Consultation Response from KC, Conservation & Design**2023/93495 Land rear of, Yorkshire House, South Street, Dewsbury, WF13 1JT****Erection of hotel (within a Conservation Area)****Date Responded: 7.10.2024****Responding Officer: Sue Brooks****Responding Ref:**

This consultation response follows the previous comments submitted for 2022/92313.

Drawing Number:  
**21-055-52**

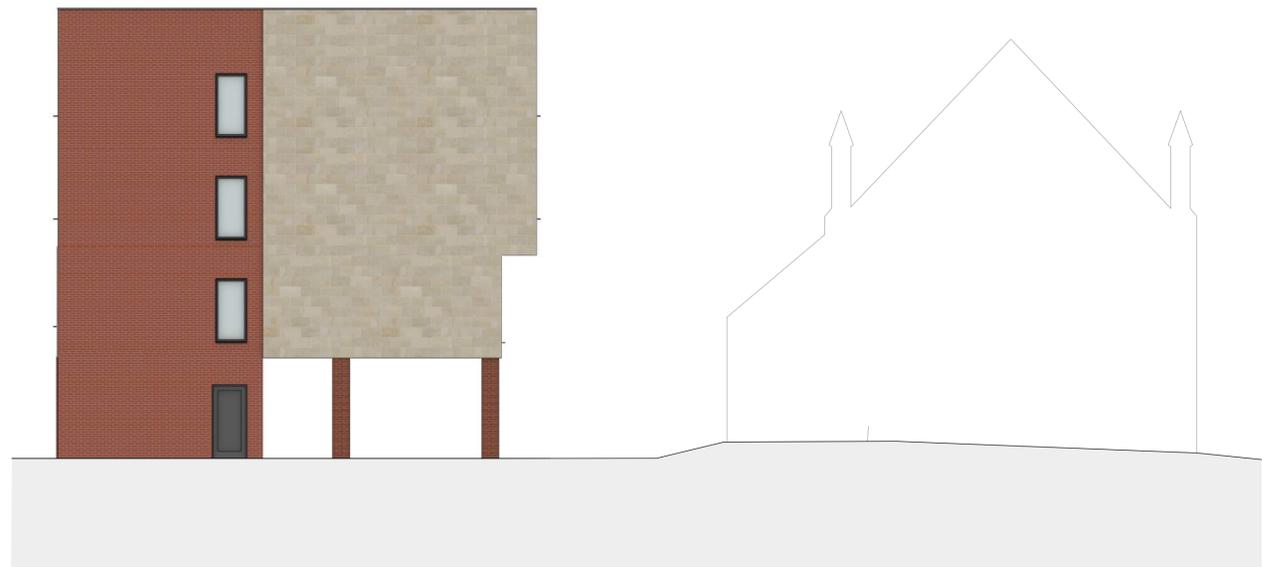
As stated in our previous response, NPPF Paragraph 197 requires local authorities to take account of the desirability of new development making a positive contribution to local character and distinctiveness. Although reduced in scale, we feel that the building is still at odds with the local character, with a flat rather than pitched roof, stone rainscreen cladding which we presume to be ashlar, and a lack of architectural detailing to the external elevations as well as an unusual design in this context, with the building set onto columns. We still consider the building to dominate the surrounding street scene, particularly the former school building, and we consider it to make a negative contribution to the local character.

We consider that a building more reminiscent of the traditional stone buildings within the immediate vicinity would be more suitable in this location and we would prefer a more traditional design, perhaps further reduced in scale with a pitched roof and coursed hammer dressed stone, and with window surrounds. We feel that, despite the amendments, the design and scale of the building do not respect or enhance the character of the townscape or the setting of the nearby heritage assets which are identified above and therefore the proposed development is contrary to policies LP24 and LP35 of the Kirklees Local Plan.

Drawing Number:
21-055-50B

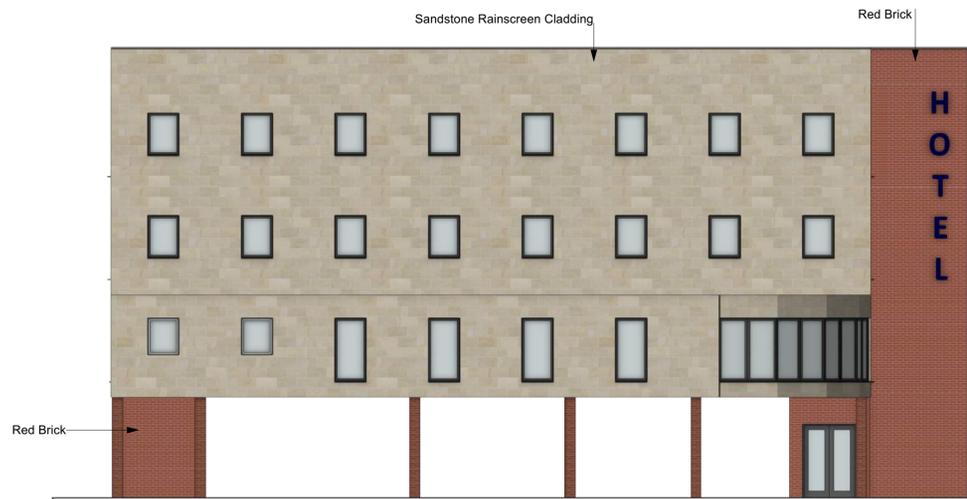
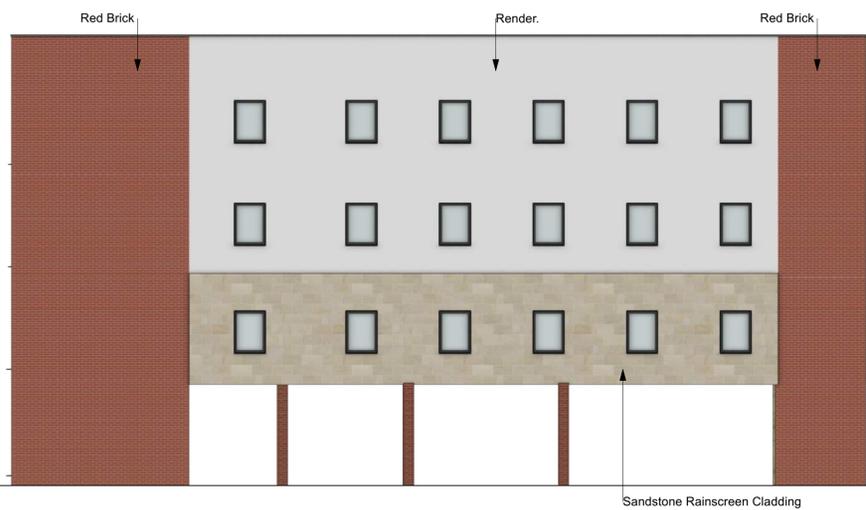
The applicant proposes a hotel on the site of the car park adjacent to Yorkshire House. A previous application was submitted and refused for a six-storey hotel, which would have dominated the setting of the former school. This has been amended to the current application which is for a four-storey building supported on columns with a small open car park beneath the building. The building has a flat roof and ranges of windows with no apparent architectural detailing to the surrounds. The external materials were previously red brick and render and have been amended to red brick and sandstone rainscreen cladding on the front and side elevations with a rendered rear (west) elevation, with grey uPVC windows.
